23 October 2017

## **Implications of proposed Parramatta Light Rail on 3 Parramatta Square**

The following comments relate to the proposal for the Parramatta Square Light Rail Stop outlined in the Parramatta Light Rail Stage 1 – Westmead to Carlingford Environmental Impact Statement, August 2017.

Figure 5.16 Indicative plan – Parramatta Square stop

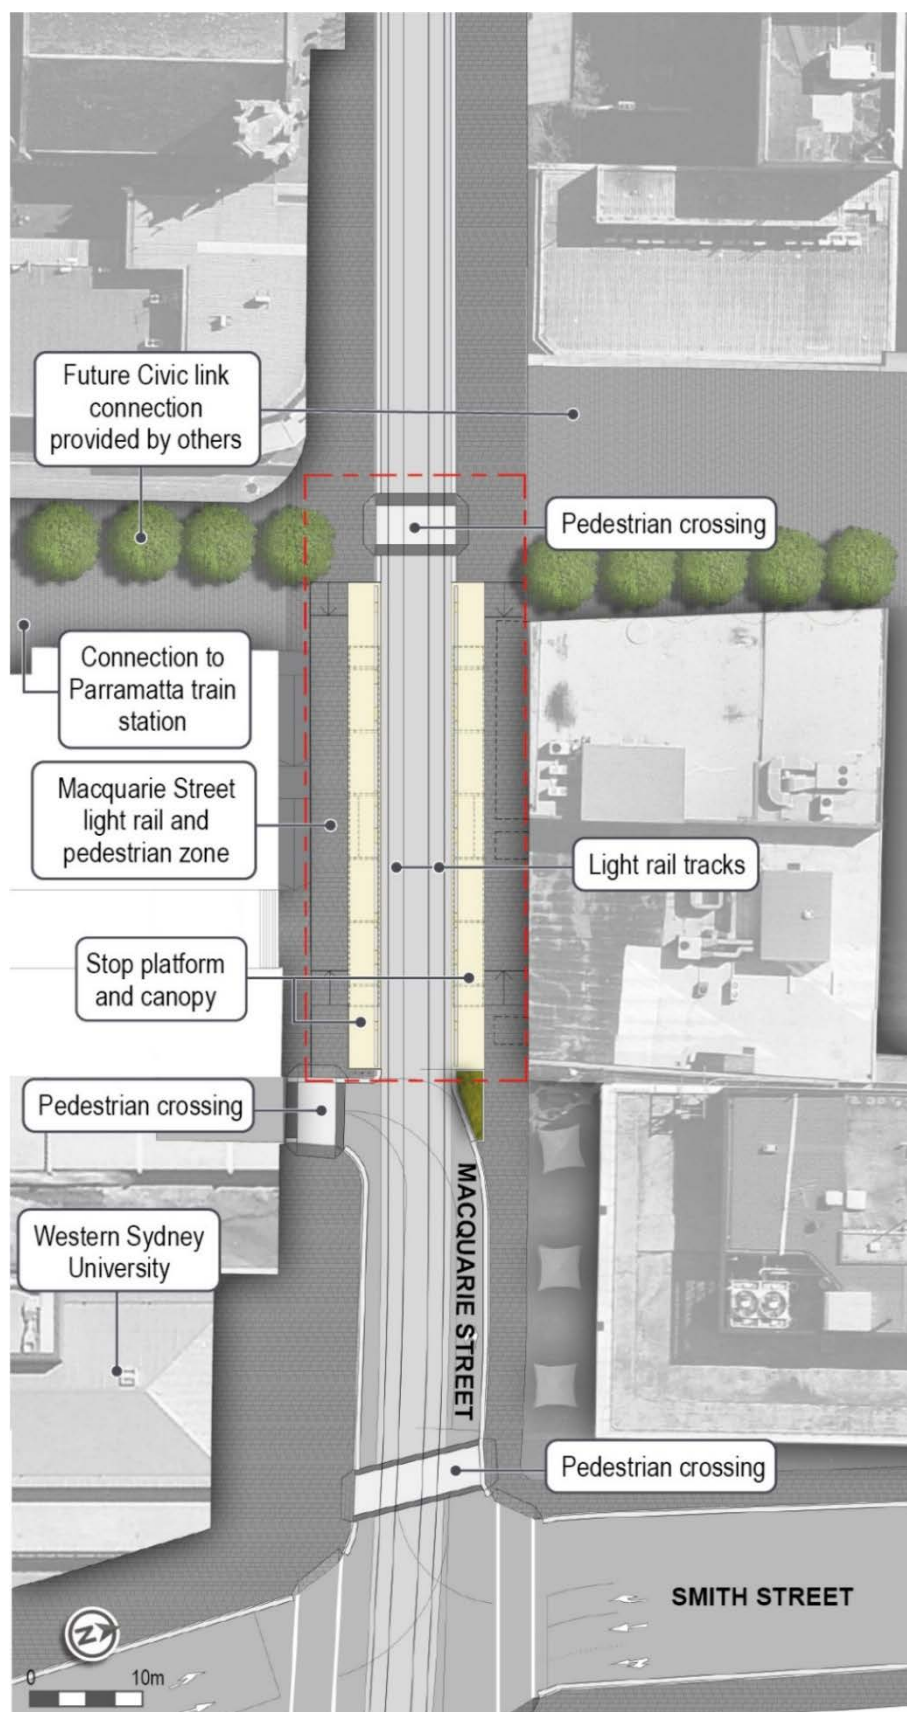
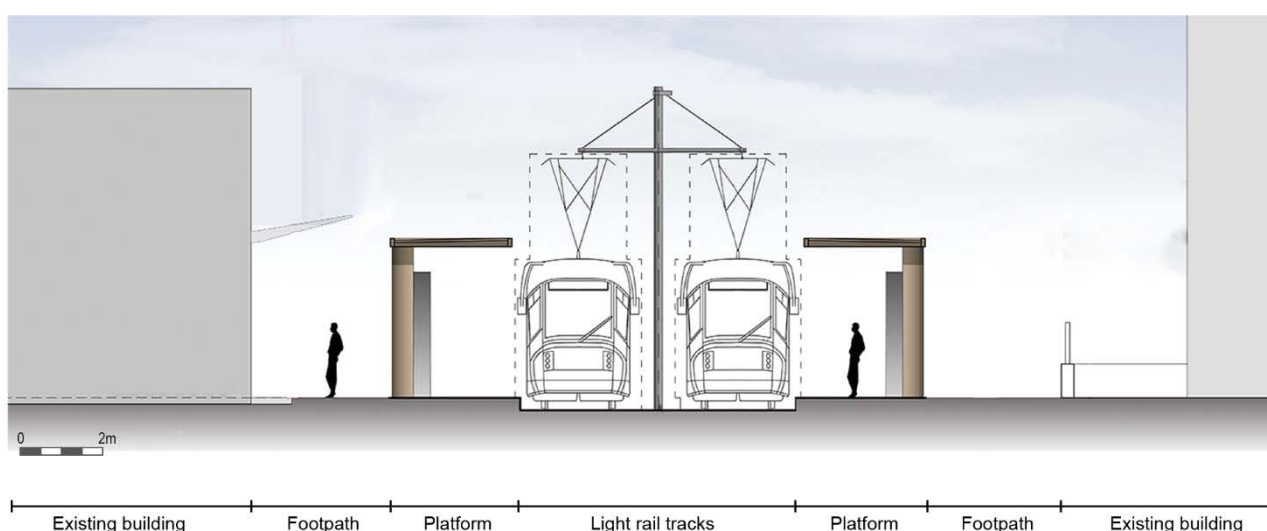
The proposed stop is too large, in width and length, for the proposed location.

The scale of the stop effectively separates the west and east sections of Macquarie Street, and does not provide adequate circulation space for pedestrians to move between Parramatta Square and Smith Street, which is an important pedestrian desire line between the heavy rail station and the commercial CBD core to the northeast.

The proposed stop layout presents a range of detrimental outcomes for the public domain and buildings surrounding the proposed stop:

- > The proposed arrangement with two side platforms (rather than a central platform) reduces the pedestrian pavement width at this key pedestrian interface – a central platform or staggered side platforms, with the platform on the southern side of Macquarie Street moved to the western side of the Civic Link
- > The eastern end of the southern platform is directly adjacent to the access point for the shared basement for the Parramatta Square development. Traffic movements in this location will be considerable, and the movement of pedestrians into and out of the platform in close proximity to the basement access point is dangerous and undesirable

An alternative location for the Light Rail Stop, further west along Macquarie Street adjacent to Centenary Square, may present an opportunity to avoid some of the undesirable urban design and pedestrian outcomes stated above, and should be investigated in further detail in conjunction with advice from TTPA traffic consultants. The scale and layout of the rail stop should also be reviewed as part of this study in order to inform an optimal outcome for the integration of light rail infrastructure within the precinct and the city of Parramatta.
